Reference No:	2024/62/92322/W
Site Address:	24, Dryclough Avenue, Crosland Moor, Huddersfield, HD4 5JU
Description:	Demolition of garage and erection of extension to side and rear with associated alterations (retrospective)
Recommending Officer:	Molly Storer

HOUSEHOLDER DELEGATED REPORT

Application Number	2024/92322
Location	24, Dryclough Avenue, Crosland Moor, Huddersfield, HD4 5JU
Proposal	Demolition of garage and erection of extension to side and rear with associated alterations (retrospective).
Publicity end date	29 th February 2024
Number of representations received	None.
Kirklees Local Plan Allocation/Designation	Unallocated in the Kirklees Local Plan
Extension to Time (EoT)	Yes EoT Date: 6 th December 2024
Recommendation	Conditional Full Permission

Proposed Grouped +
Plans & Elevations

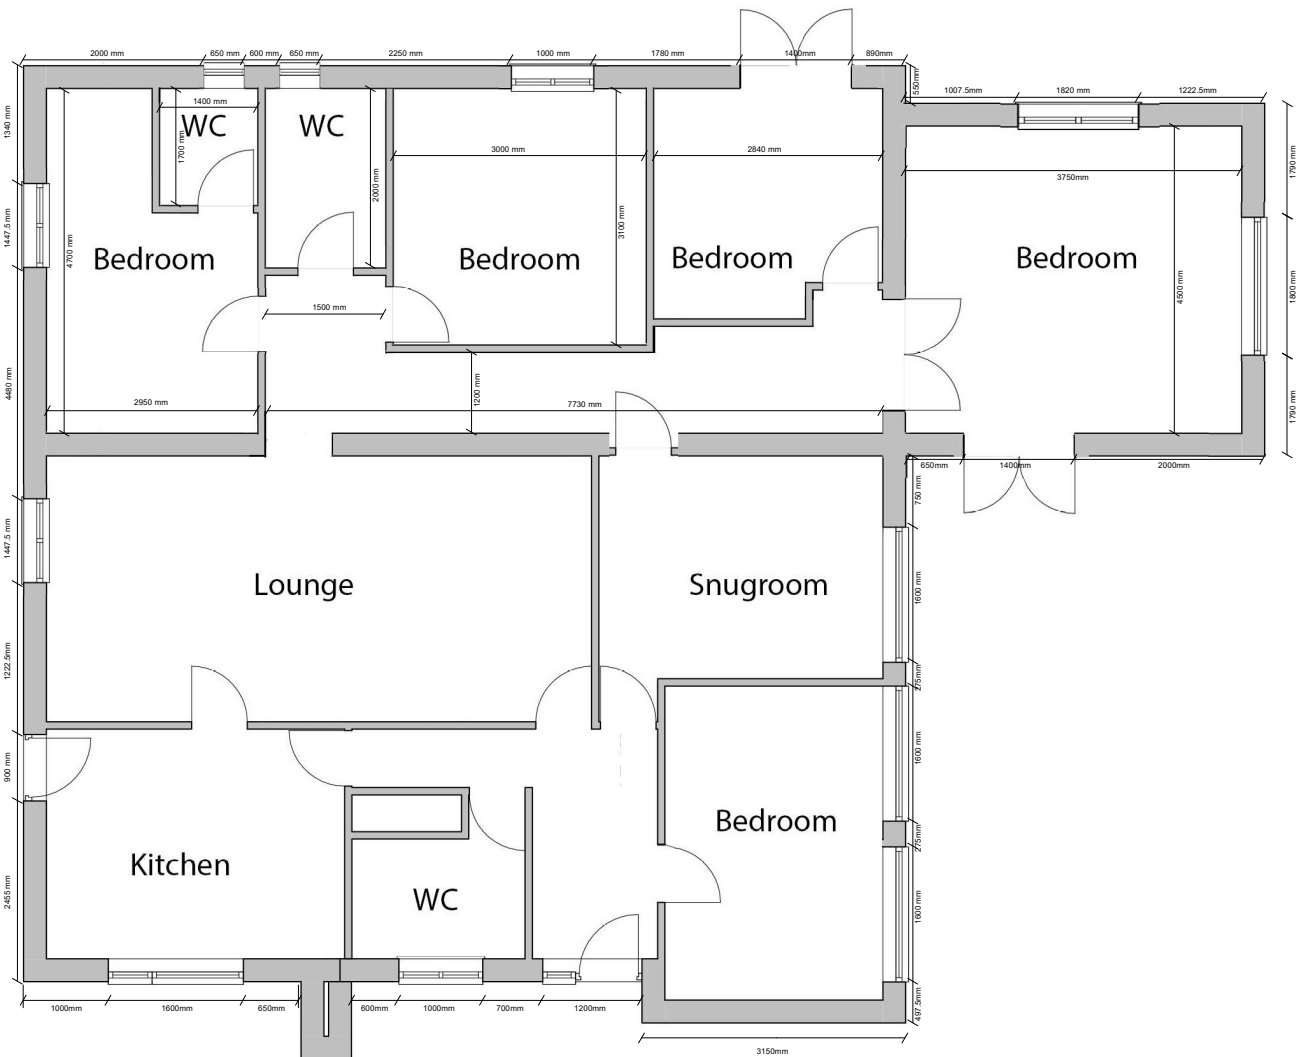
YES / NO	SUMMARY
Negotiations/Amendments during course of application	Yes	Concerns were originally raised with the agent with regard to the fully glazed doors facing No.22 as it was considered that this may cause a significant level of overlooking to the neighbouring property. The agent responded with plans to show a 6 foot timber fence between No.22 and 24 to create a division for visibility and privacy. It was also stated that these fully glazed doors will be replaced with obscure glazing to further protect privacy.
Parish/Town Council comments sought (Kirkburton)	Yes	
Planning History	No	
Consultations required	No

the Kirklees Local Plan and the NPPF		
Impact on privacy of neighbours (to sides, rear and front)	• KDP 3 & 4 of the SPD • Policy LP24 Design (d) (iv) • Chapter 12 of the NPPF	There were originally privacy concerns with regard to the glazed doors looking onto No.22. However, the agent provided plans to show a 6 foot timber fence between No.22 and 24 to create a division for visibility and privacy. It was also stated that these fully glazed doors will be replaced with obscure glazing to further protect this neighbours privacy. This is now considered acceptable.	✓
Impact on light and outlook of neighbours (to sides, rear and front)	• KDP 4, 5, 6 of the SPD • Policy LP24 Design (b) • Chapter 12 of the NPPF	The extension will be located primarily to the rear of the applicant property. This means that due to the orientation of the properties there will be a separation distance of 15m to the property at No.22. due to this and the single storey nature nit is not considered to cause significant overbearing or overshadowing impact to this neighbour.	✓

Summary of Representation	Officer response	Addressed ✓ / X / N/A
Objection - Glazed door for the bedroom would look directly into neighbouring property.	The agent has provided plans to show a 6 foot timber fence between No.22 and 24 to create a division for visibility and privacy. It was also stated that these fully glazed doors will be replaced with obscure glazing to further protect this neighbours privacy. This will be attached as a condition on any grant of approval.	✓

4. The double door within the side, north elevation of the side extension upon submitted plan titled Proposed Grouped + Plans & Elevations (ref: A104) shall be obscurely glazed.
